Rezoning Transportation Analysis

Petition Number: 2021-178

General Location Identifier: 07706303

Revision Log:

SHEET NUMBER:
RZ-1

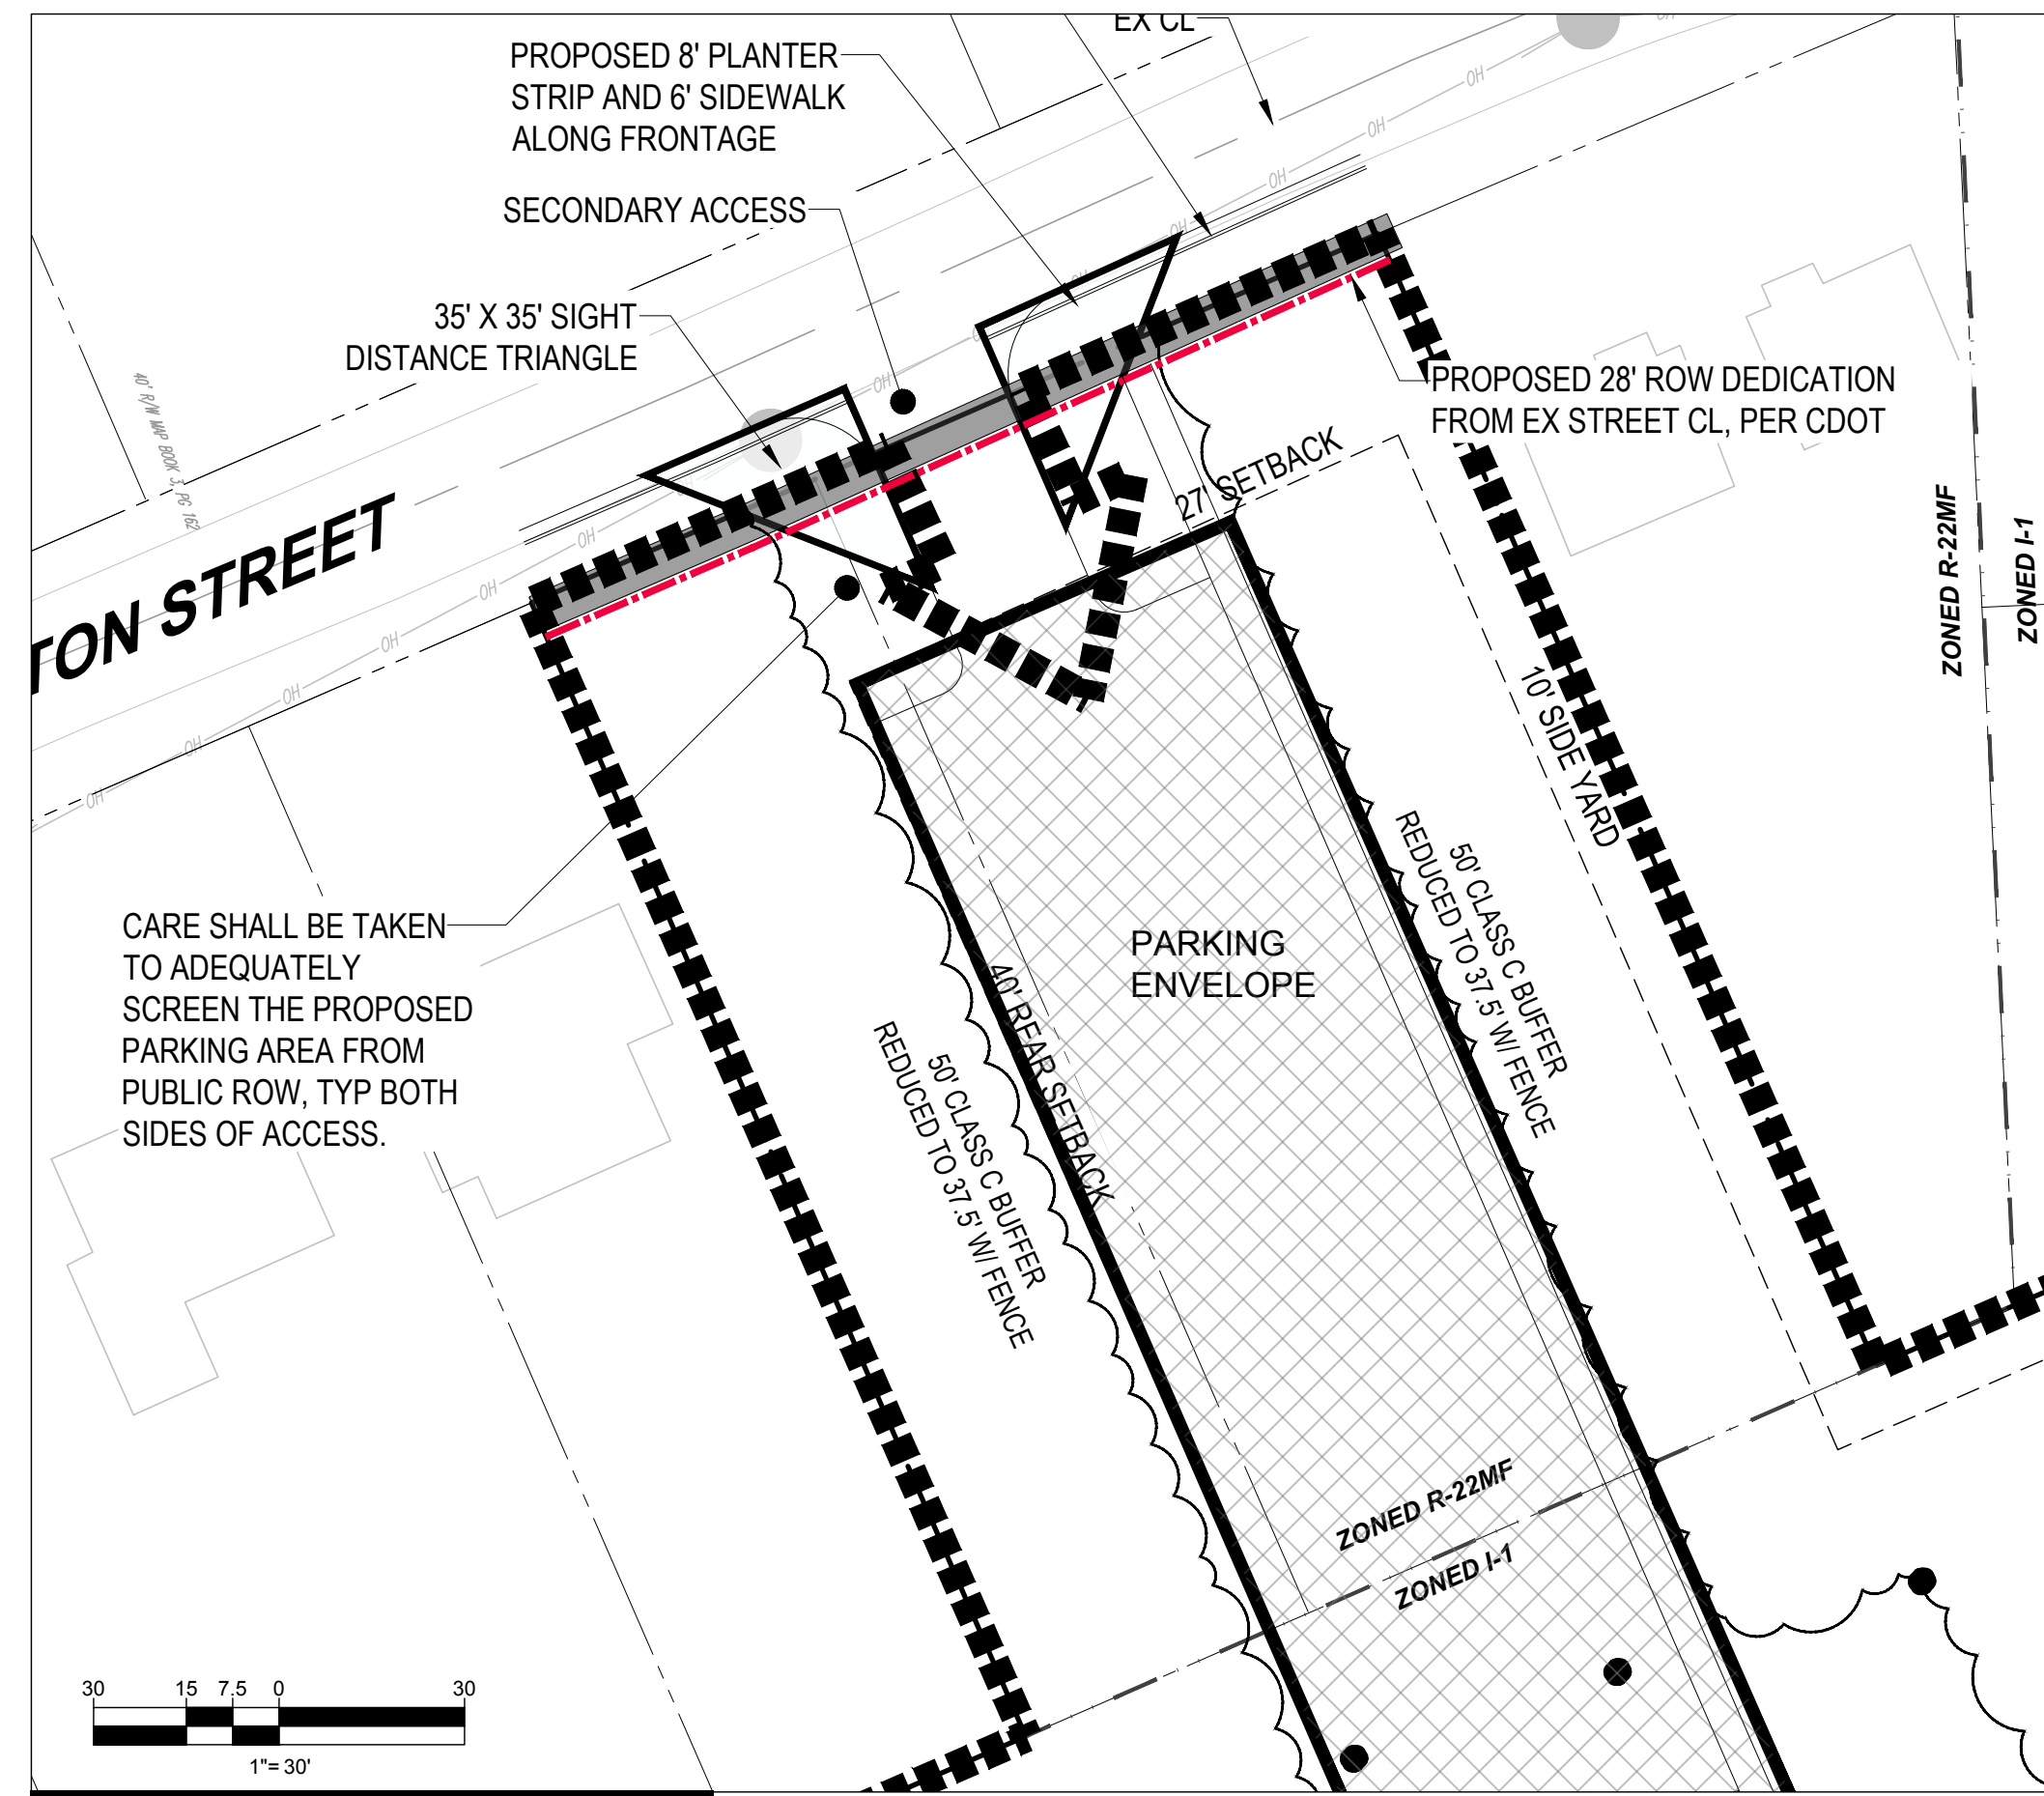
Label and dimension the curb and gutter from the centerline for each road on the site plan.

3. ~~Revise site plan and conditional note(s) to commit to dedicate 28 feet of right-of-way from the road centerline of Whittington Street. The site plan shall label and dimension the right-of-way from the road centerline.~~
~~Outstanding Comments from 11-21-21:~~ Show centerline of Whittington Street on site plan and dimension the proposed ROW from the centerline.

4. ~~Revise site plan to label and dimension right of way on Statesville Avenue and Atando Avenue.~~
~~Outstanding Comments from 11-21-21:~~ Show centerline of Statesville Avenue on site plan and dimension the proposed ROW from the centerline.

12. ~~Outstanding Comments from 11-21-21:~~ Dedicate greenway easement for future Irwin Creek Greenway. Coordinate with Mecklenburg County Parks and Rec for location of easement. In addition, coordinate with County on easement dedication for greenway spur to JT Williams Montessori School from future Irwin Creek Greenway.
